Subject: RE: Planning Re-Consultation on: Y/70/22/DOC

Application No: Y/70/22/DOC
Registered: 30th May 2022
Site Address: Land at Bilsham Road Yapton
Grid Reference: 497547 102838
Category: Discharge of Condi
Description of Works: Approval of details reserved by condition imposed under ref Y/91/17/OUT relating to Condition Nos 9 - surface water drainage and 27 - levels.

I am able to inform you that I have received an amendment to the above application dated 19th December 2023 relating to: SUBSTITUTE FOUL AND SURFACE WATER DRAINAGE

Drawing Status	FOR APPROVAL
Client	THAKEHAM
Project	BILSHAM ROAD YAPTON
Drawing Title	PROPOSED FOUL AND SURFACE WATER DRAINAGE LAYOUT
Scale	1:500
Date	Feb 22
Drawn By	LDF
Checked By	MJA
Drawing No.	D1956-13-102
Rev.	B

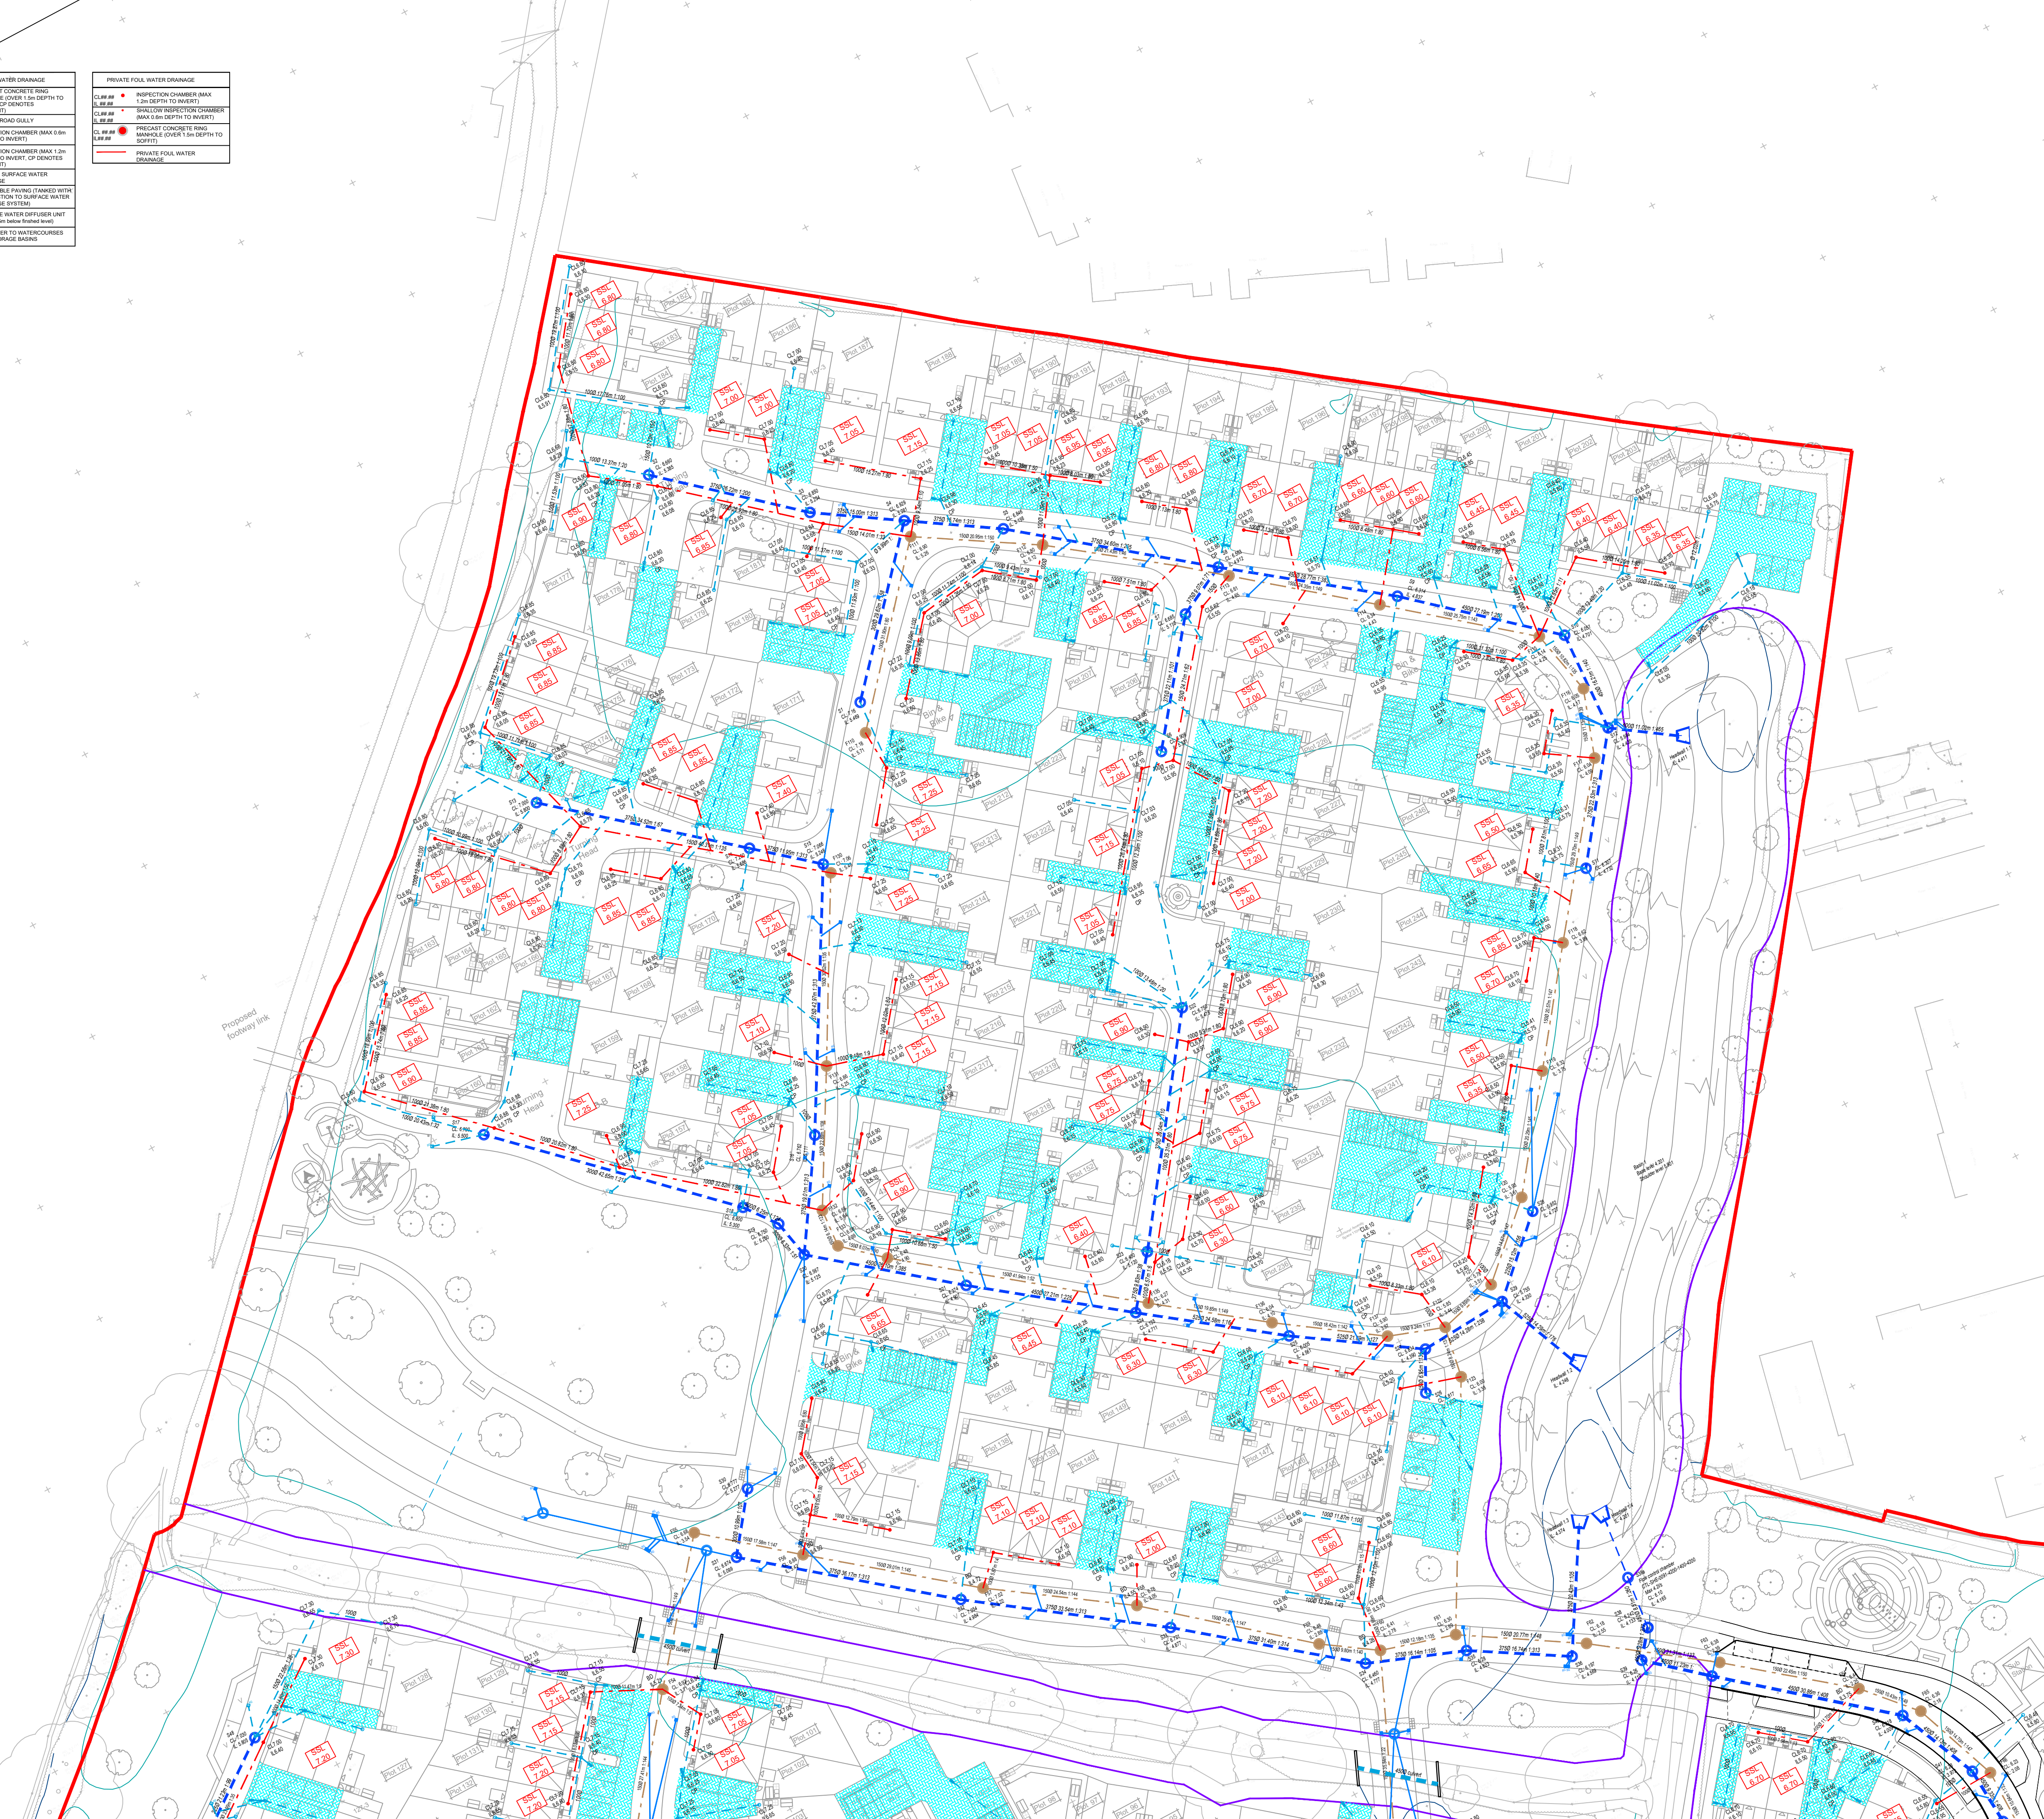
Please can you ask the applicant or their designer to provide a design specification for when they believe tree root protection is necessary for drainage infrastructure. I have done a very basic preliminary assessment of the updated drainage layouts and the specification and placement of tree root barriers appears to be inconsistent.

It would be helpful to understand where the designer feels that barriers are necessary to protect pipework, inspection chambers, permeable paving and other infrastructure. This will help us to assess if the design meets their own specification.

For example, is there an arbitrary distance of any tree trunk from infrastructure where a barrier would be necessary? Is that distance different depending upon the type of infrastructure that is being protected? Or does the use of barriers relate to the potential growth of the tree and its roots?
